Please ask for: Ms Iqraa Malik
Email: iqraa.malik@terraquest.co.uk
Telephone: 0121 234 1390
Our Ref: AW/307/21/HH
Your Ref:
Date: 13th September 2021

Application for Planning Permission for Works or Extension to a Dwelling

Development: Resurface front driveway, install an additional soakaway and replace the cement edging blocks
(This application may affect the character and appearance of the Craigwell House, Aldwick Conservation Area)

Location: 11 The Drive Aldwick PO21 4DU

Block Plan 11 The Drive PO21 4DU

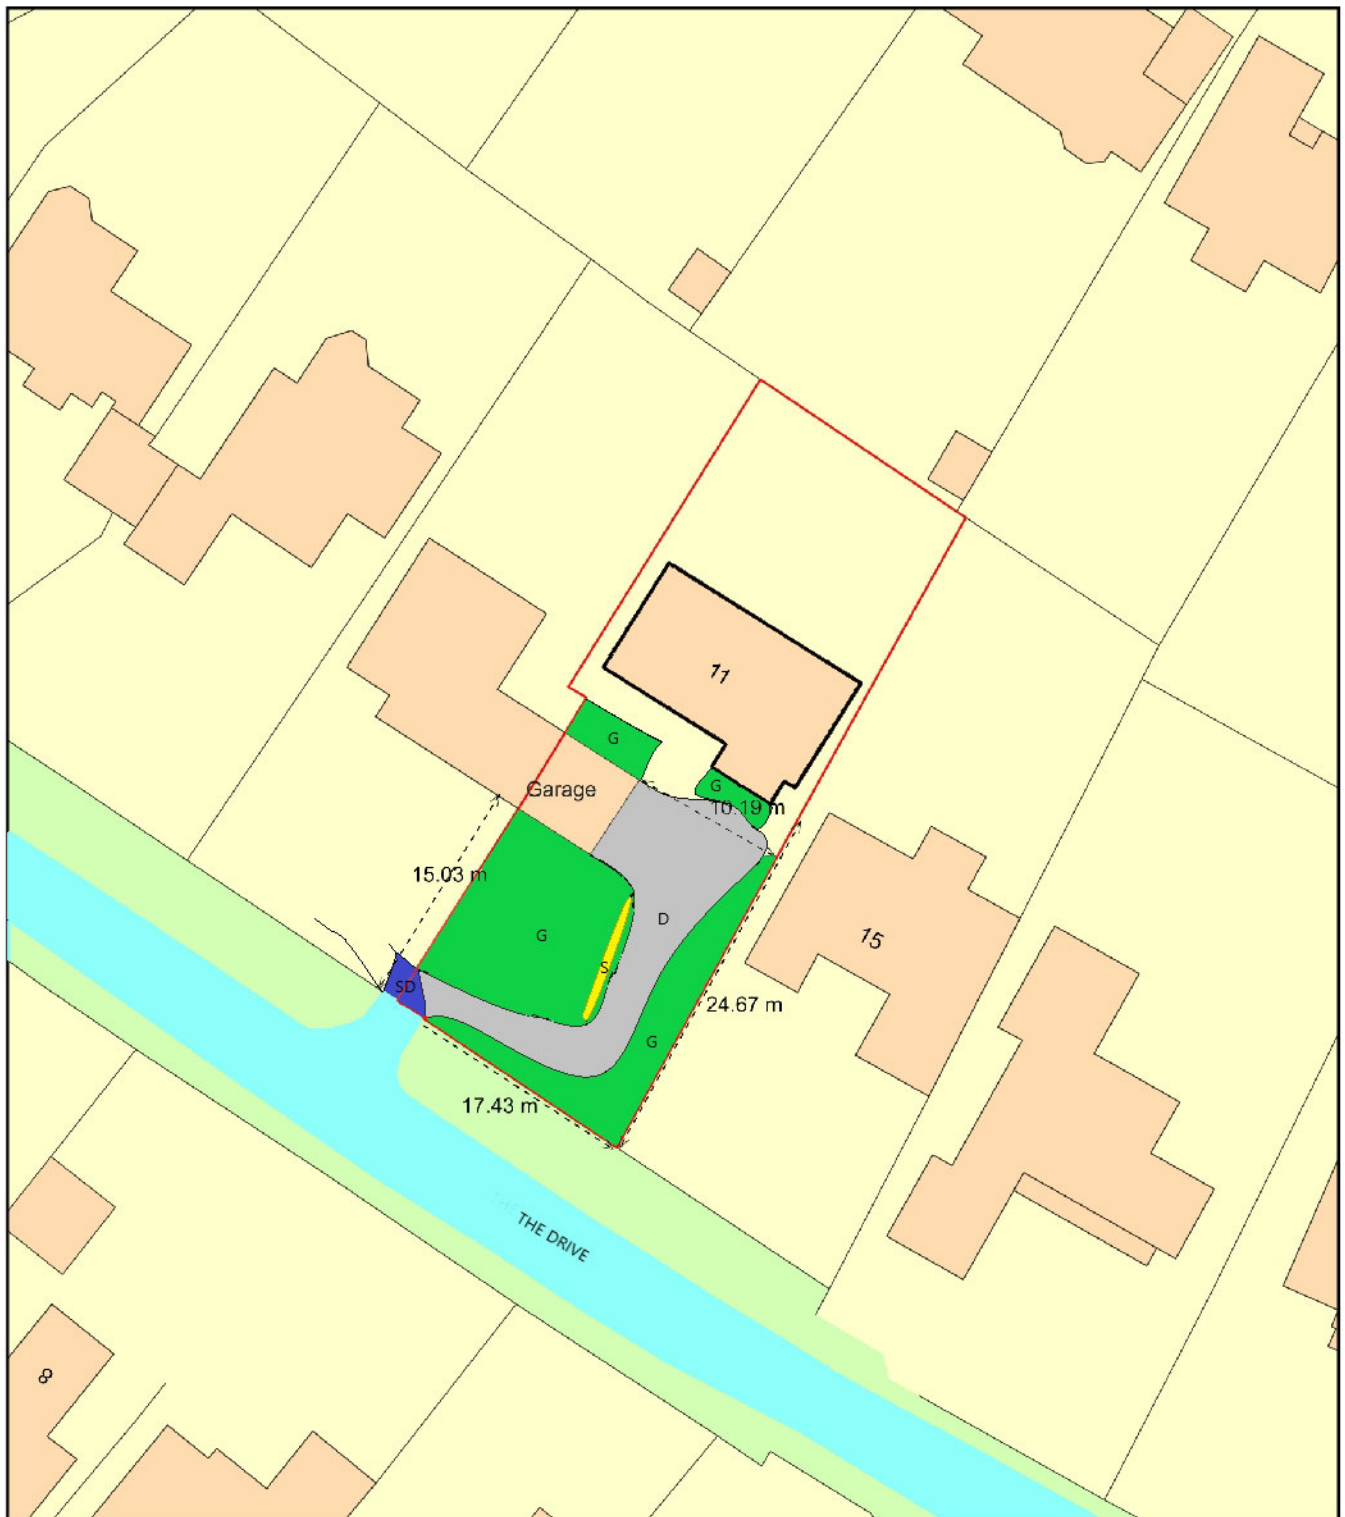
Please submit a block plan at a scale of 1:500. Further details of what must be included on the plan can be found in the Validation Requirements List.

Please submit a plan with the proposed works, these could be annotated on a proposed block plan, with a stated scale and a scale bar. A blue outline indicates the property is under your ownership, please confirm if this is the case for 9 The Drive as it is outlined in blue on the plan submitted.
